Tritax Symmetry (Hinckley) Limited  
**HINCKLEY NATIONAL  
RAIL FREIGHT INTERCHANGE**

**The Hinckley National Rail Freight  
Interchange Development Consent Order**  
Project reference TR050007

**Applicant's response to Deadline 6 Submissions [part 7 -  
Parish Councils]**

Document reference: 18.20

Figure 11.12: Night-time Views and Photomontages PVP 25

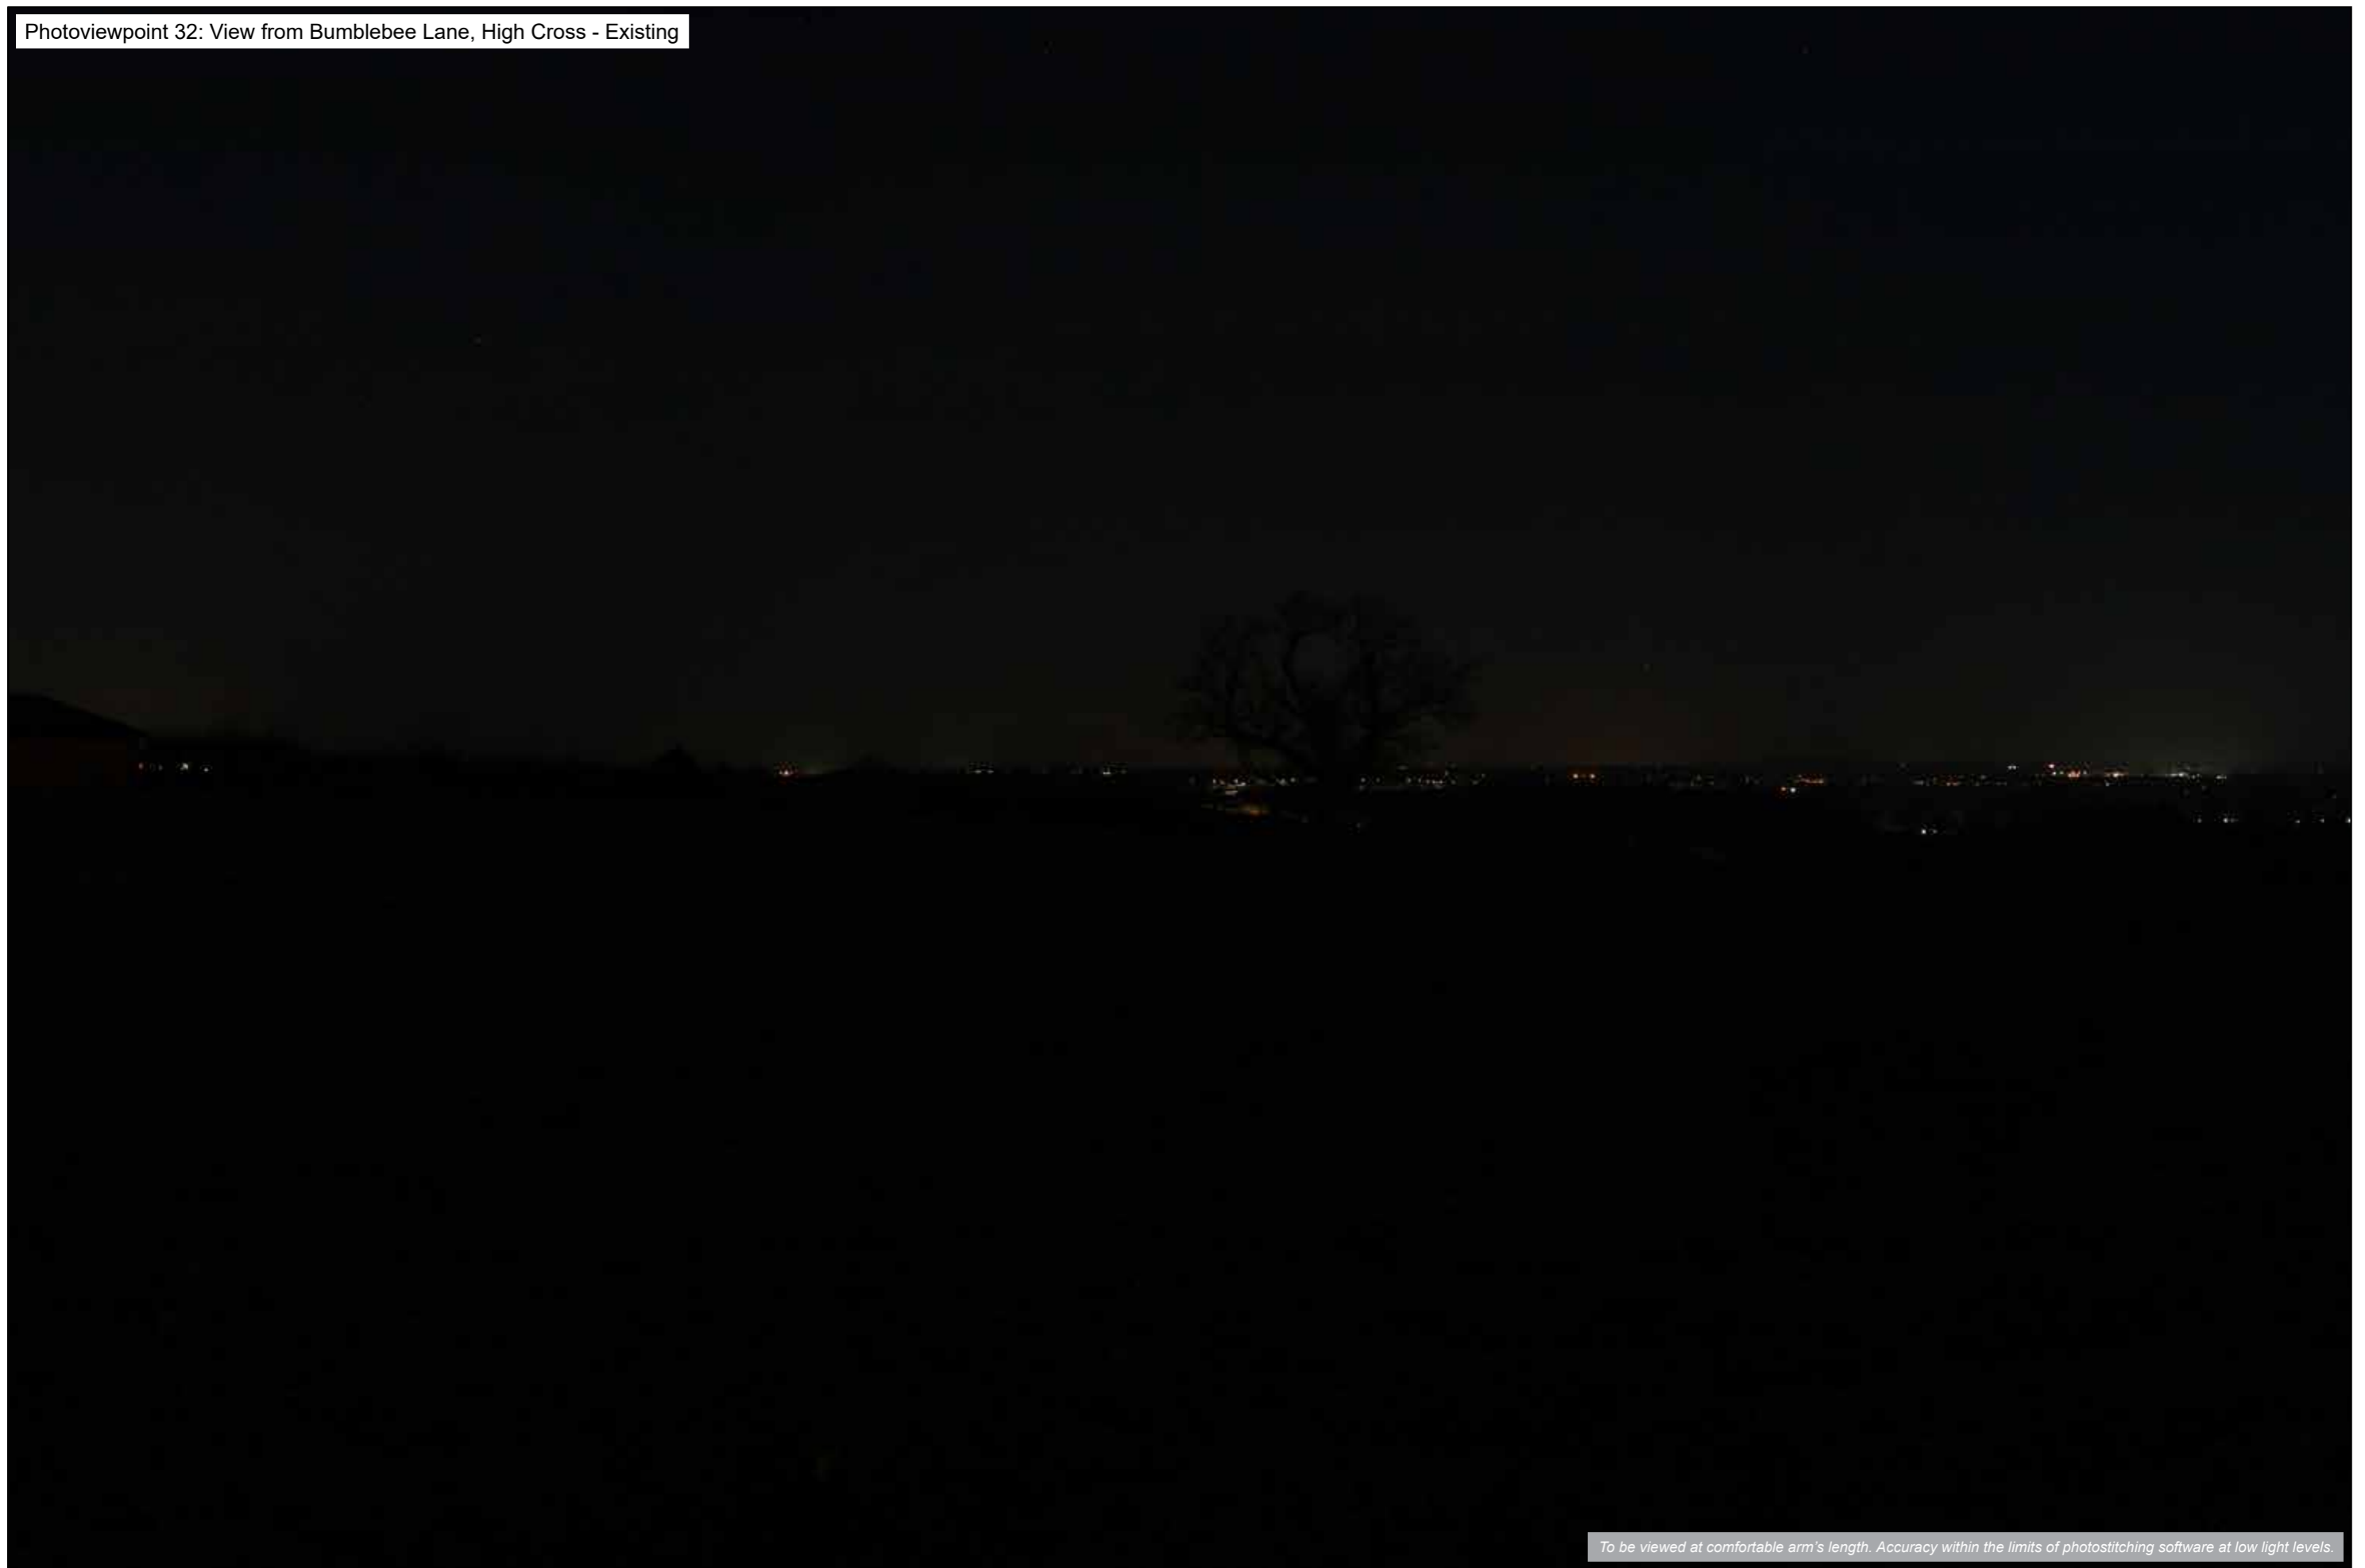
<p>4. Visual Impact</p> <p>4.1. Elmesthorpe Parish Council highlighted, at Deadline 5, the confusion surrounding Viewpoint 20 in the document 6.3.11.12a Hinckley NRFI ES Figure</p>	<p>As noted in the Applicant’s Deadline 6 Response, the change in angle between the daytime and night-time view is noted. This was not intentional and is the first time the discrepancy has been brought to the Applicant’s attention. It does not, however, change</p>

<p>11.12 Night-time Views and Photomontages. Photo Viewpoint 20 is the view from the M69 bridge B581. Standing on the M69 bridge on the B581 as per the daytime photomontages viewpoint 20, would show significant change at night. With the current error or omission in information supplied, no one is able to assess the massive scale of change in the character of the area, or the effect of the lighting on those living just 300-350m from the site itself on Stanton Lane (B581/Burbage Common Road junction). We remain interested to see this image once it had been corrected, and reserve our representations on this matter until that time</p>	<p>the nature of the assessment which does take into account the broader view as well as the impact of the motorway at night, the fleeting nature of the view from the bridge and the nature of the receptors, for these reasons this view will not be updated further.</p> <p>With regard to those living in the vicinity, the residential assessment identifies a higher significant effect on those living on the B581 to the east of the M69 (see Residential Assessment No 6, Appendix 11.6 - document reference: 6.2.11.6, REP4-063) and those living on the B581 west near the Burbage Common Road Junction (see Residential Assessment No 7, Appendix 11.6 - document reference: 6.2.11.6, REP4-063).</p>
